**Planning Department
Transportation Development Services Section**

Re: Hartman Publishing, 1313 Iron Ave. SW
Certification Submittal for C.O. – Transportation Development
Architect's Stamp dated 1-17-14 (K13-D045)
Certification dated 3-28-14

The Letter of Certification submitted on 3-28-14 is not sufficient for acceptance by this office for final Certificate of Occupancy (C.O.). The following items need to be addressed:

HARTMAN PUBLISHING
ALBUQUERQUE, NM 87102
Sheet No. **TCL**

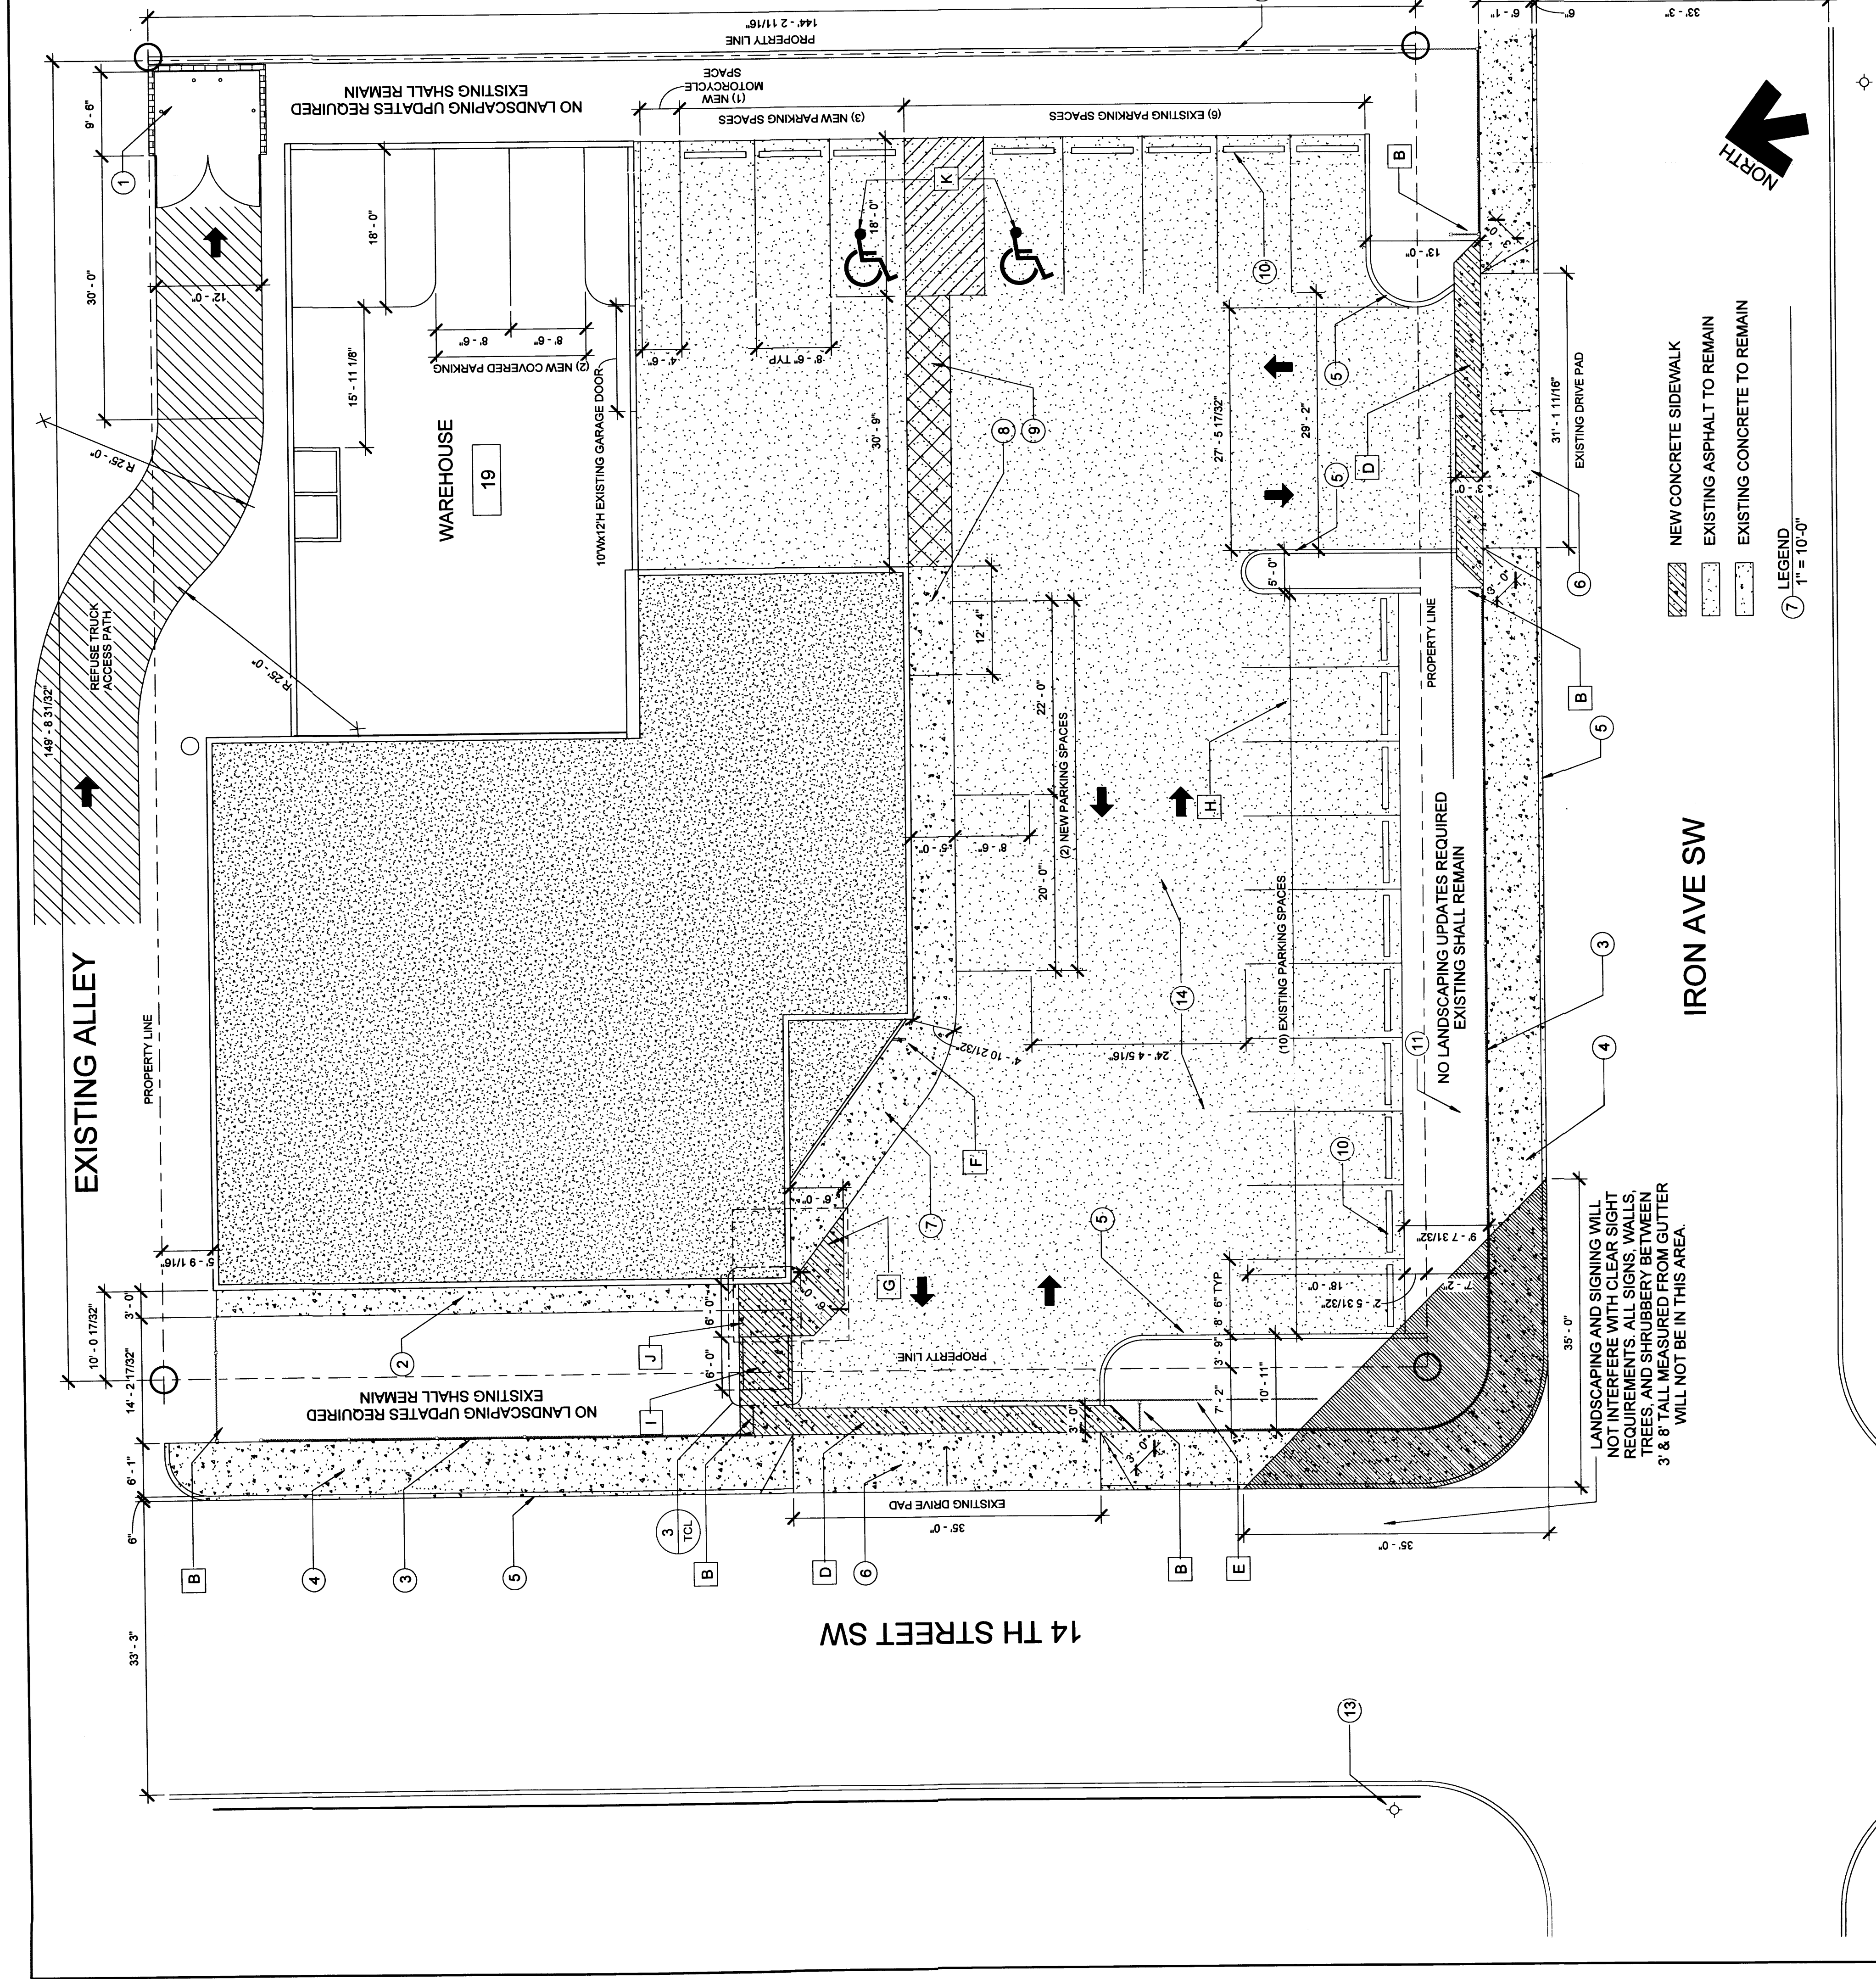
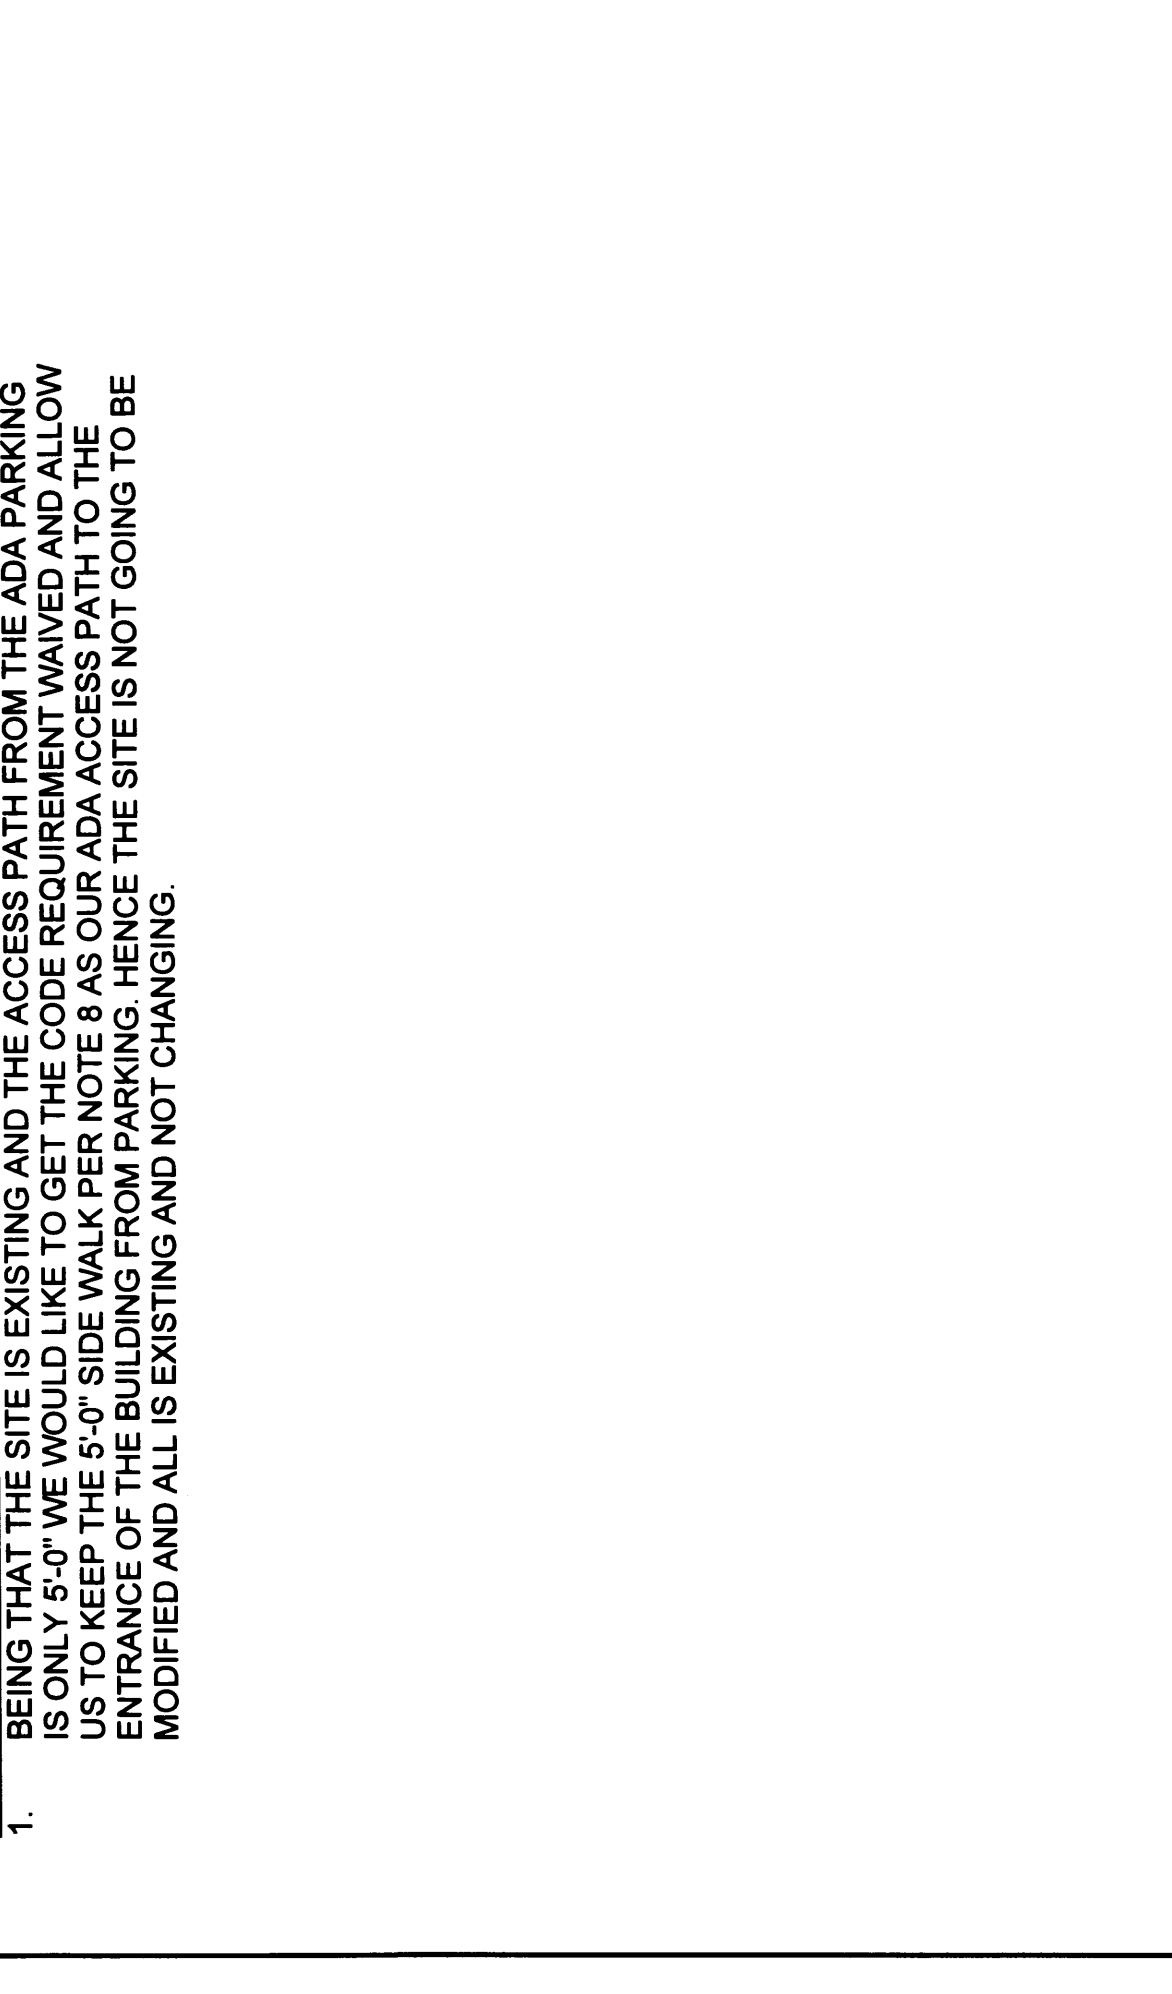
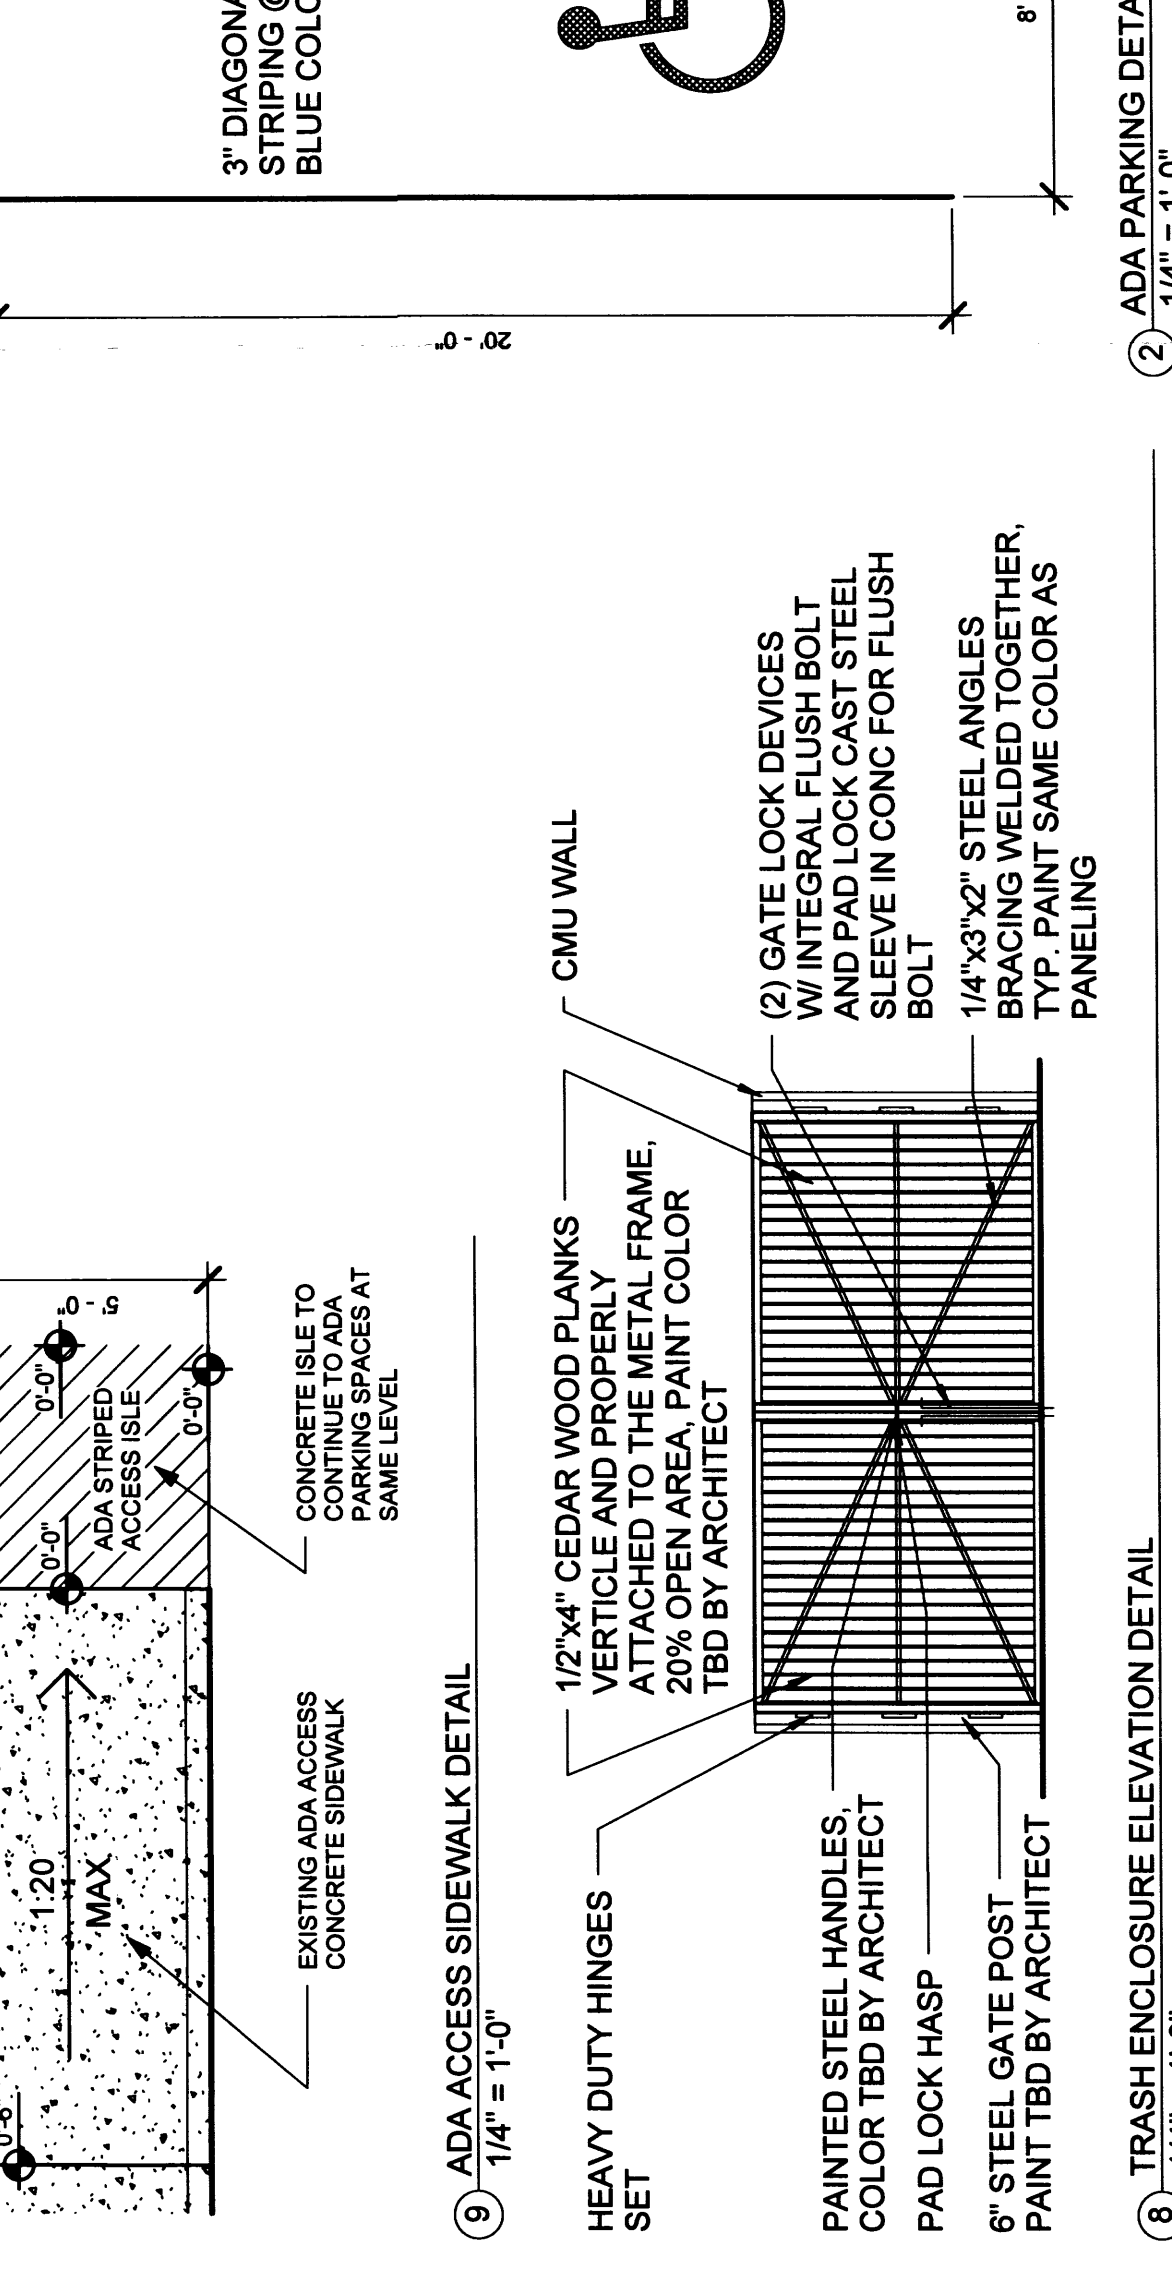
- Two new parking spaces near building need to be marked.
- Handicap parking space signs need to be installed.
- The existing drivepad on the south side of the site is very cracked and in very poor condition. In addition the ADA connection through this drive pad leads to uneven and therefore non ADA accessible sidewalk due to tree root growth. Please remove and replace the drivepad and any uneven sidewalk along the site frontage.
